LEAD LOCAL FLOOD AUTHORITY CONSULTATION – STATUTORY CONSULTATION

Consultation on Application Number: 2017/91677

Address: Land at, Serpentine Road, Cleckheaton, BD19 3NA

Proposal: Erection of 42 retirement living apartments, 83 bed care home with provision of communal facilities, landscaping and car parking and erection of 7 affordable dwellings

Drawing title  
**Drainage Strategy Layout**

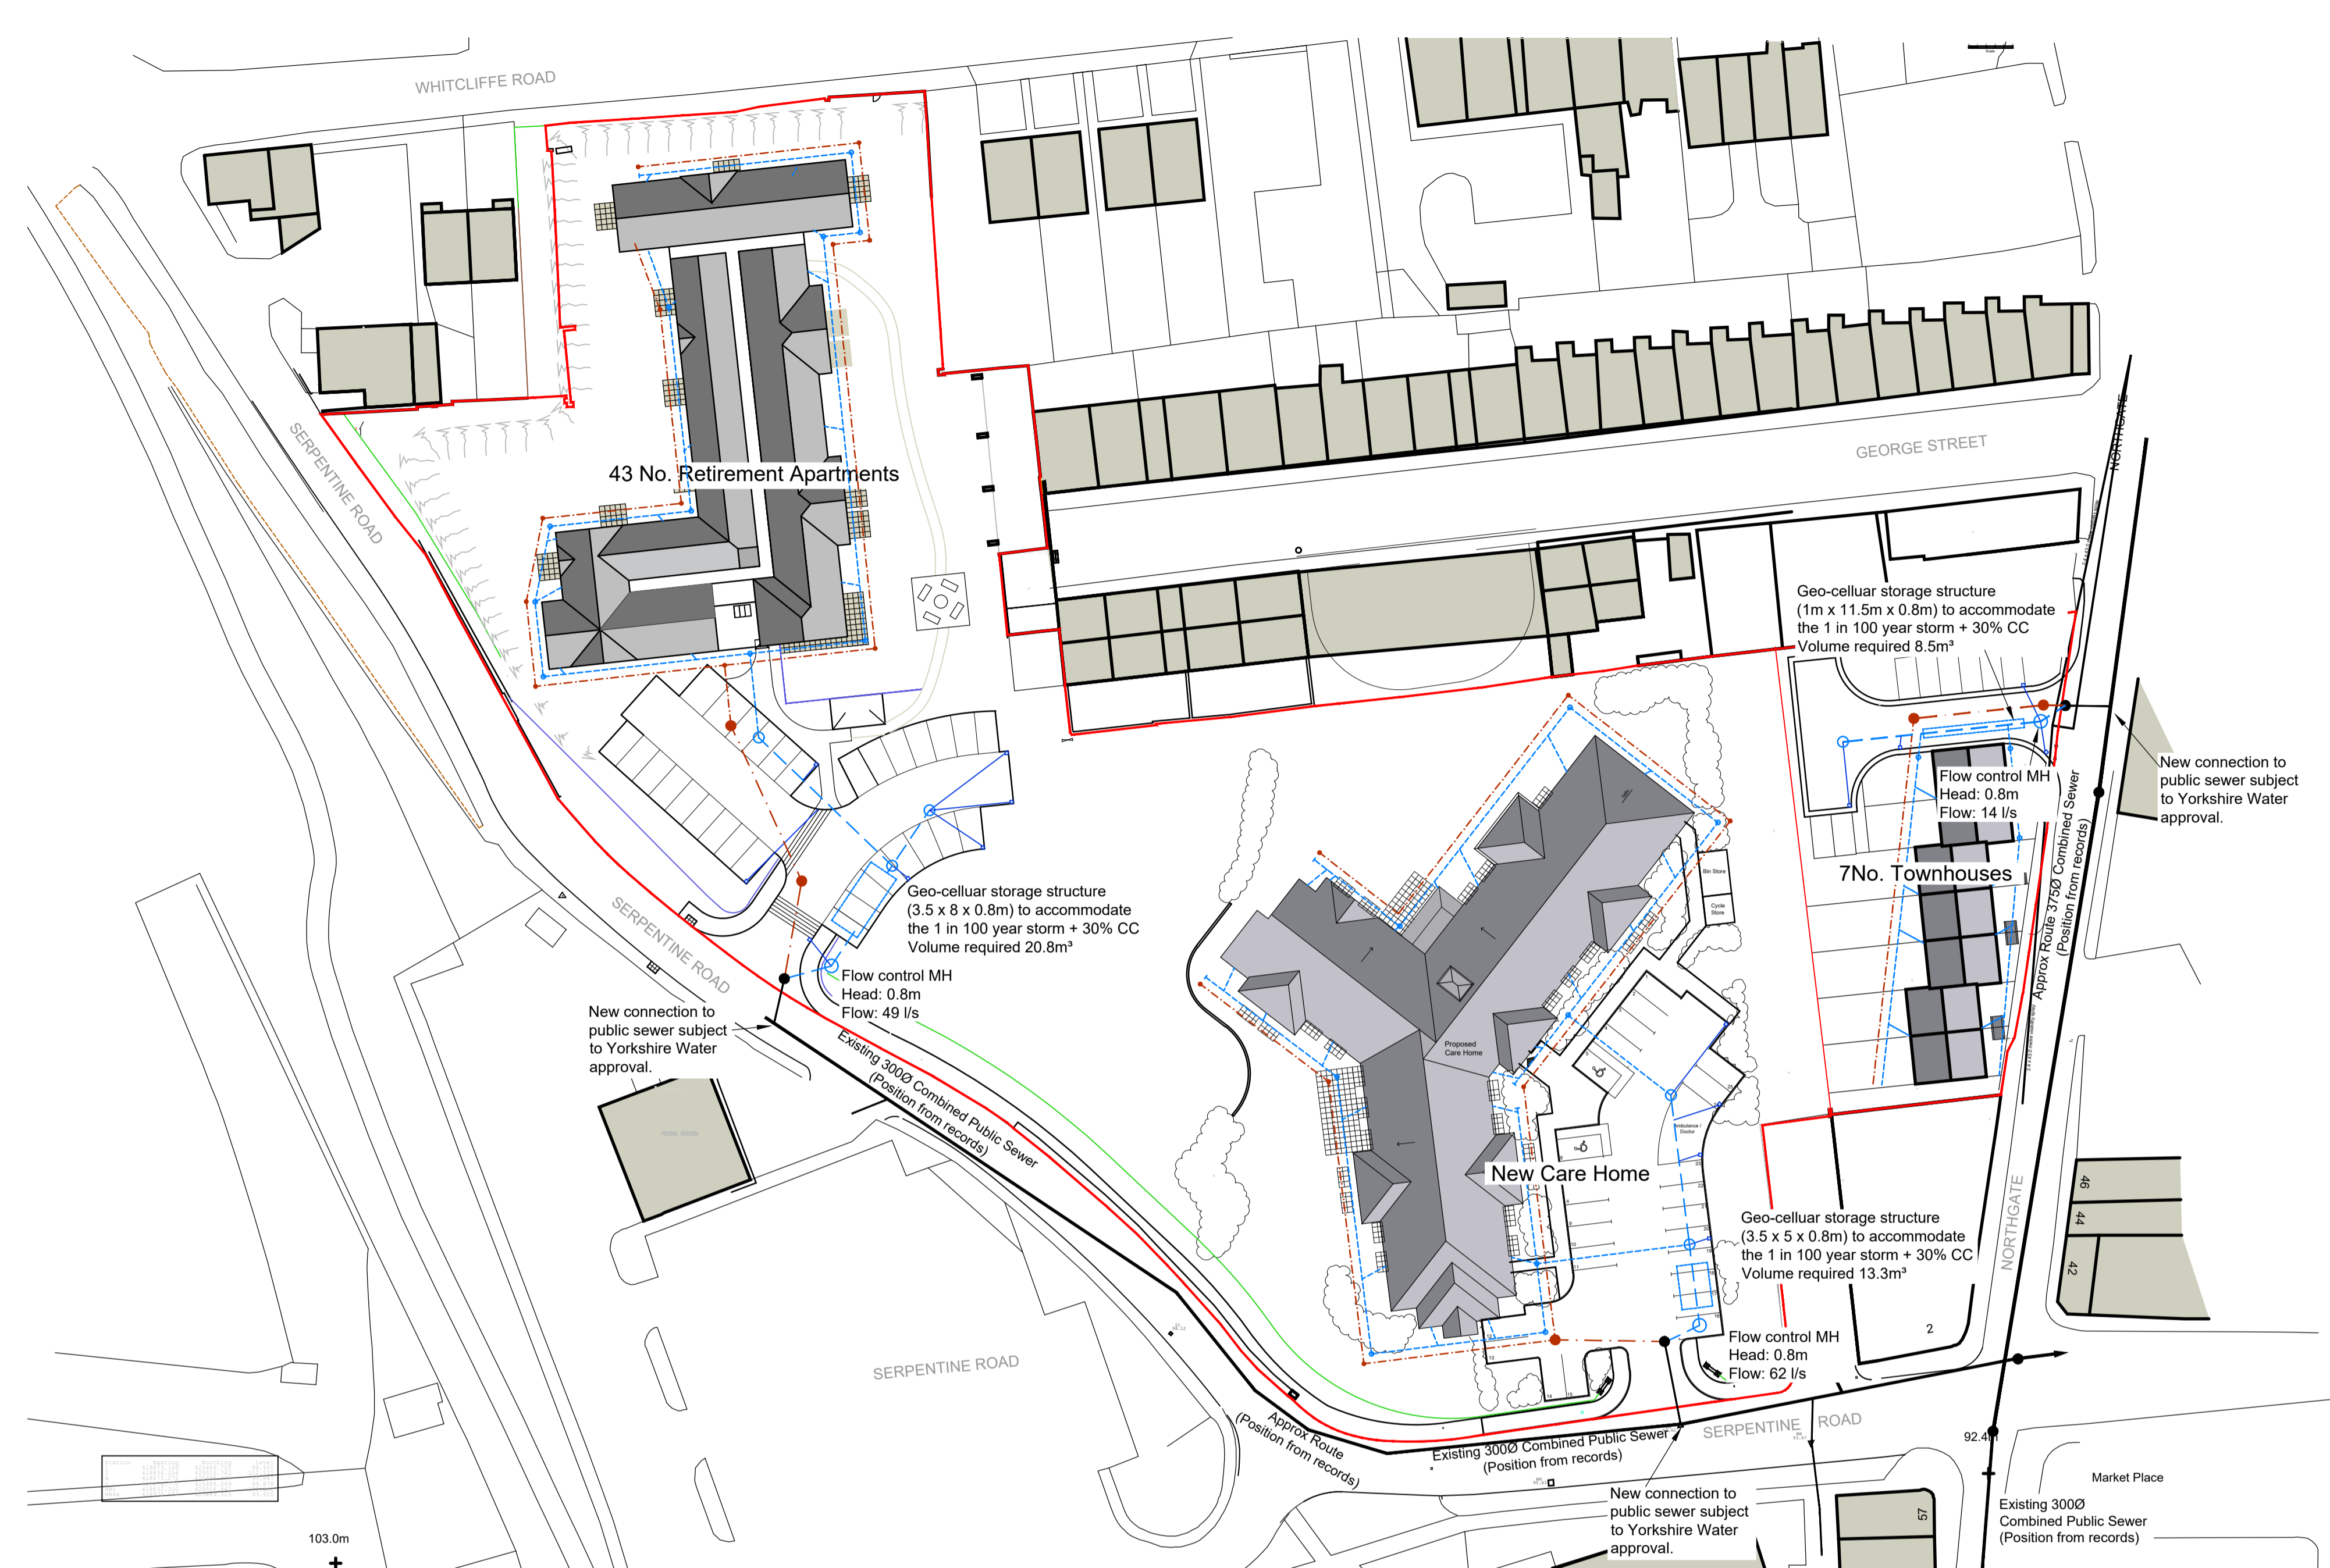
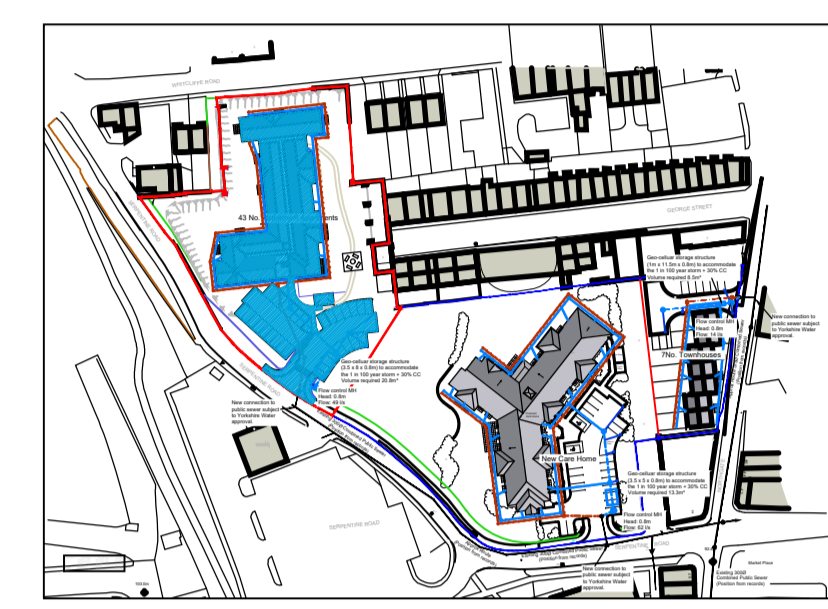
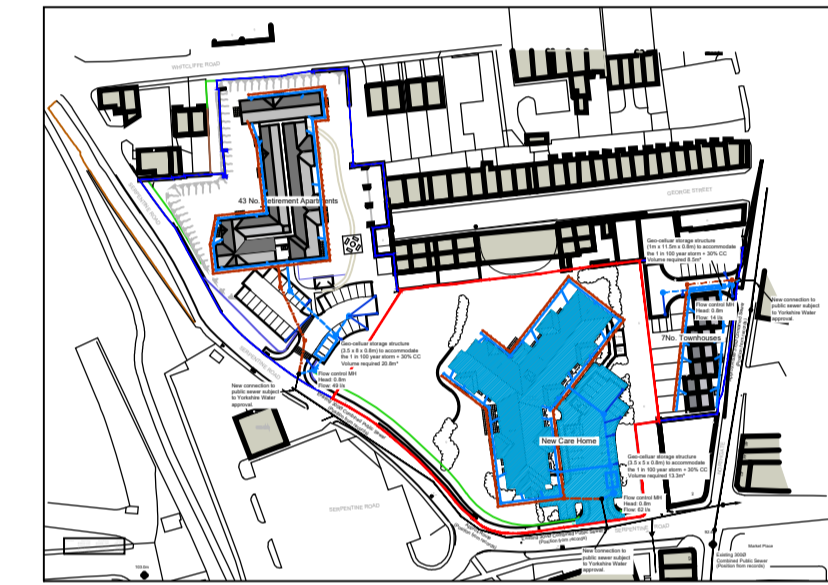
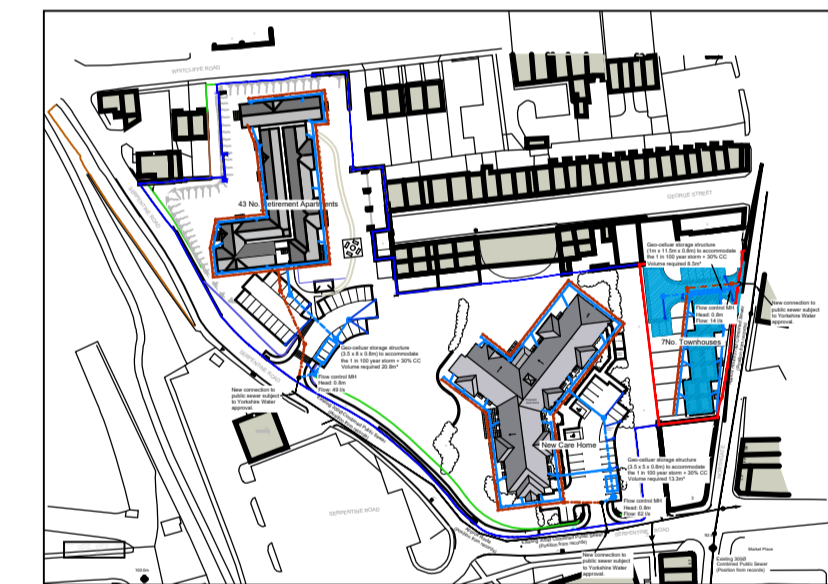
We therefore dispute the indicative drainage drawing supplies showing 49l/s, 14l/s and 62l/s = total 125l/s to the public combined sewer. We expect this figure to be lower. If however Yorkshire Water agrees a set figure to public combined sewer, then we advise the LPA that they have accepted the risk. They currently asked for evidence. **Still to examine.**
